CITY OF ALBUQUERQUE

Re: FFCU Office Building
4910 Union Way Dr. NE, 87107
Traffic Circulation Layout
Engineer's/Architect's Stamp 11-8-19 (F16D015A)

The TCL submittal received 12-19-2019 is approved for Building Permit with. A copy of the stamped and signed plan will be needed for each of the building permit plans. Please keep the original to be used for certification of the site for final C.O. for Transportation.

ACCESSIBLE RAMP - A
A1

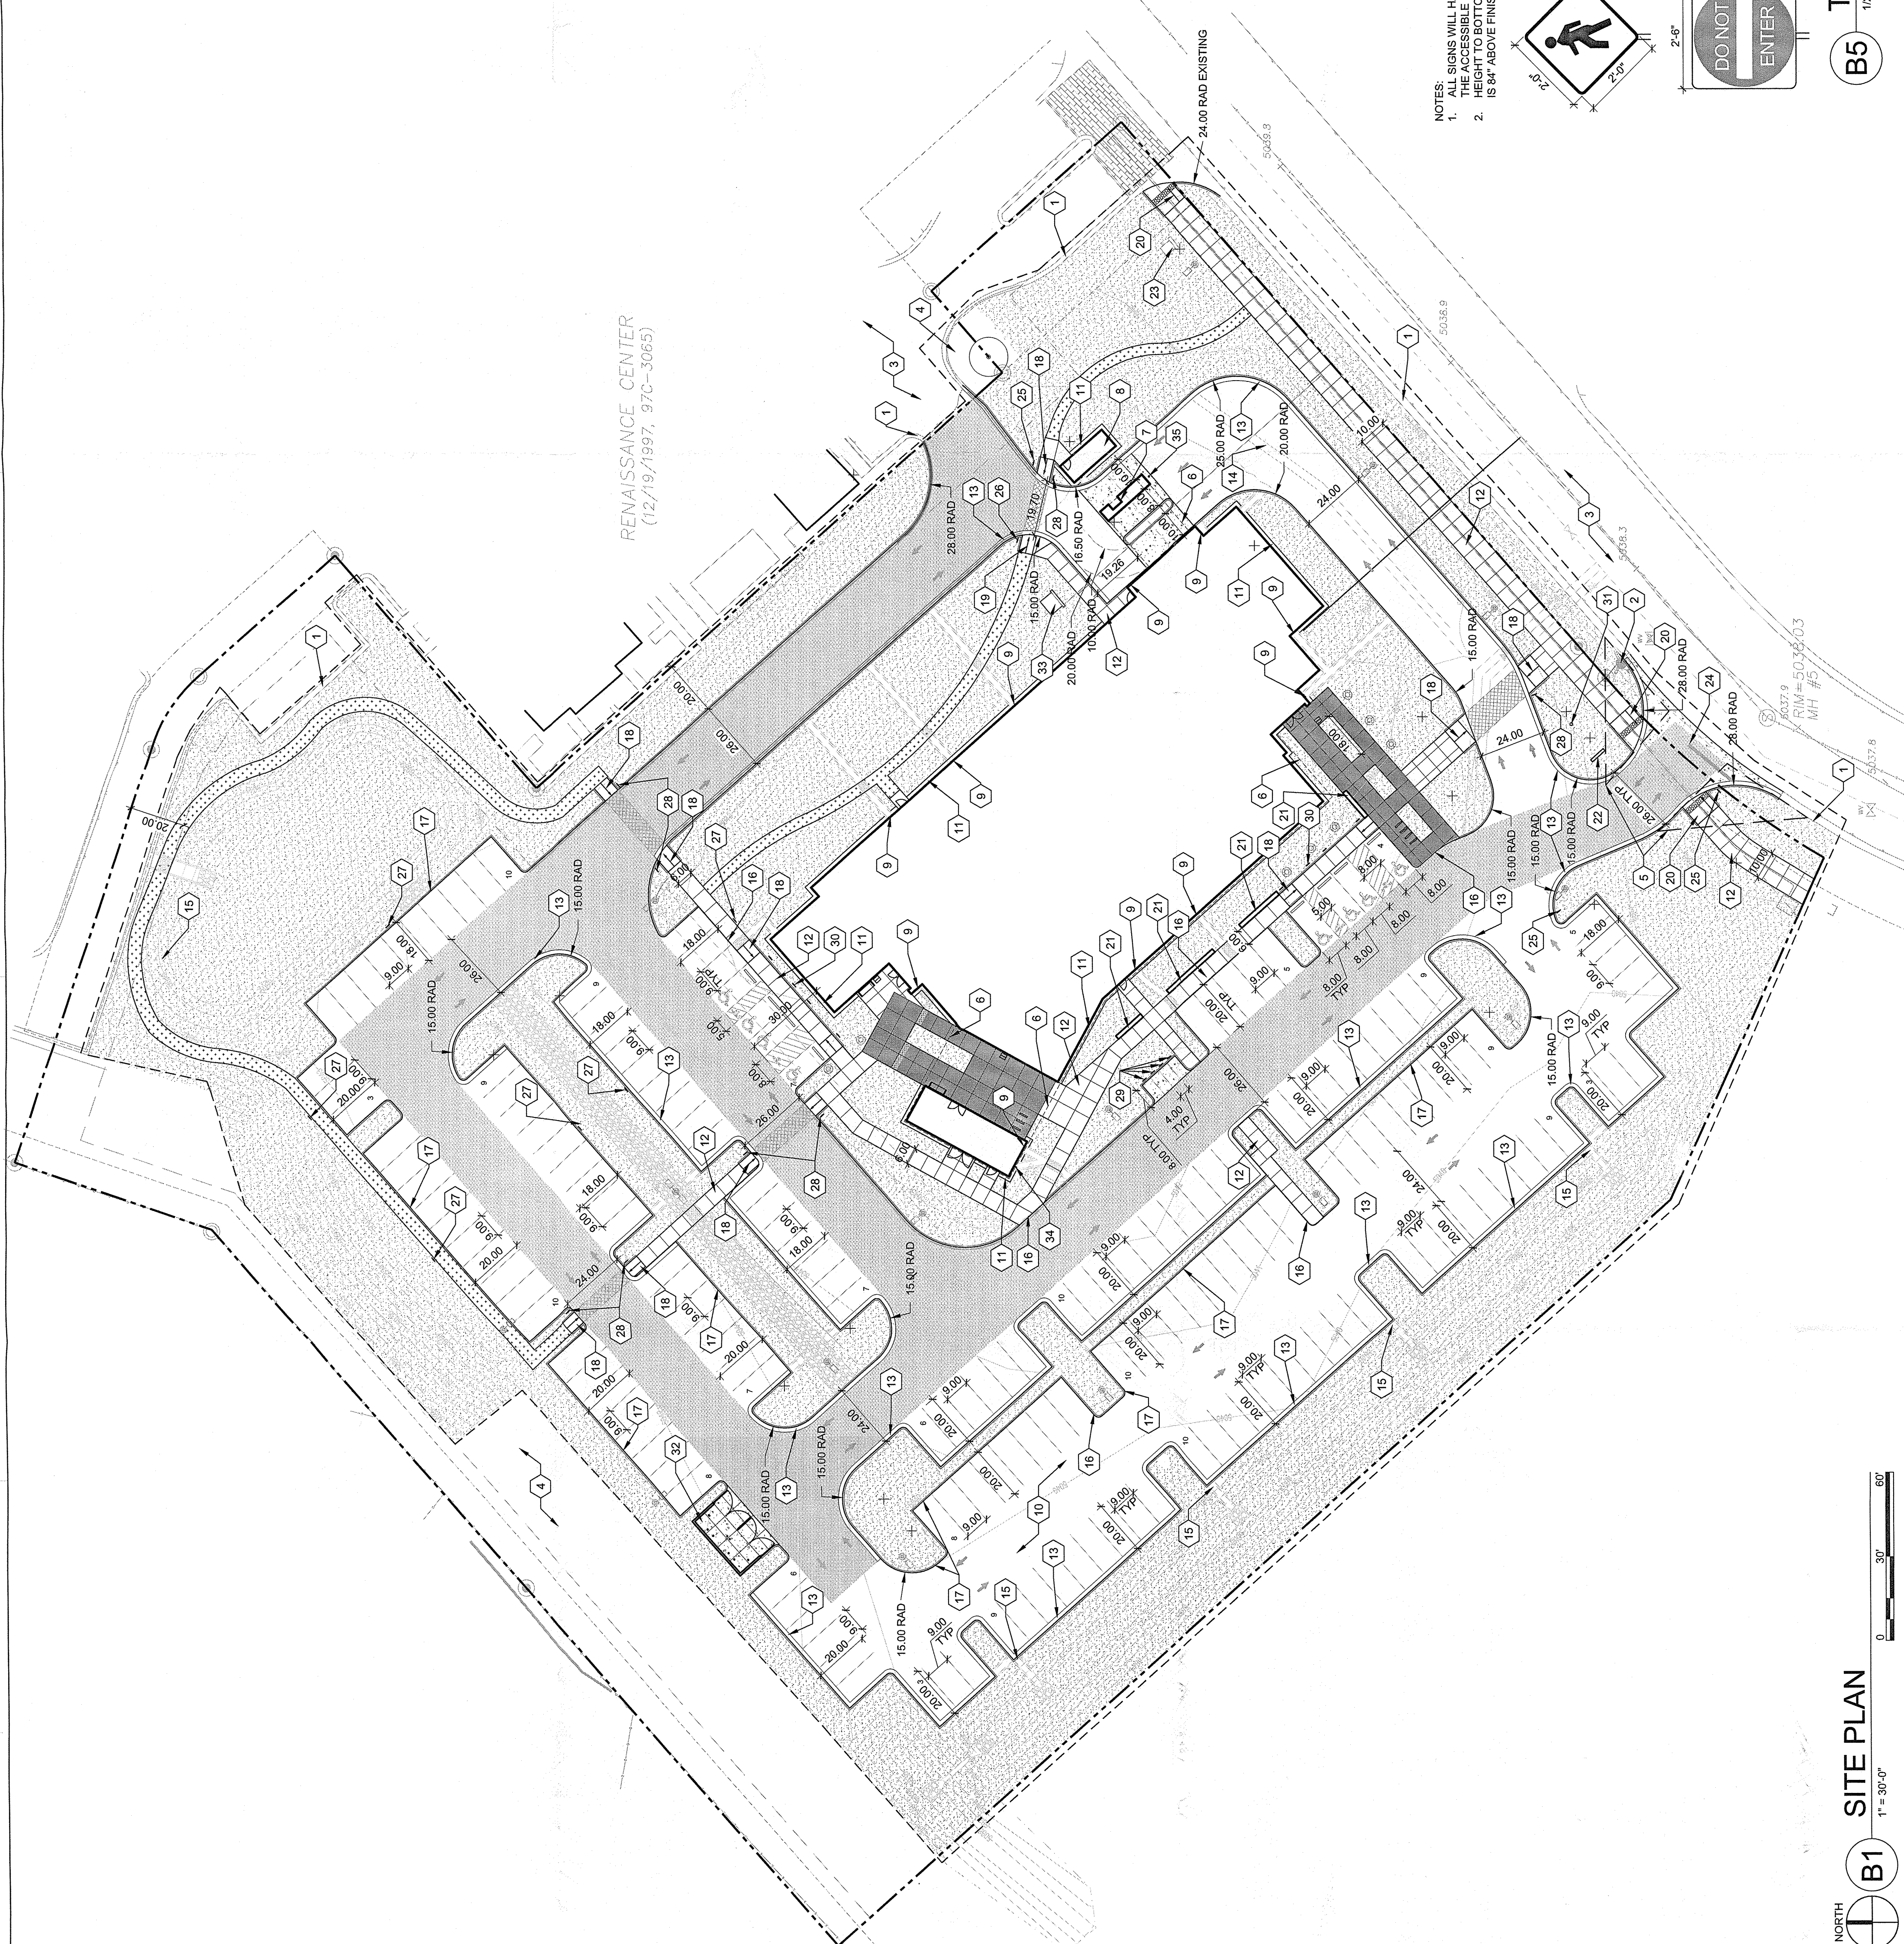
1. Prior to release of Final CO please provide sidewalk easement.
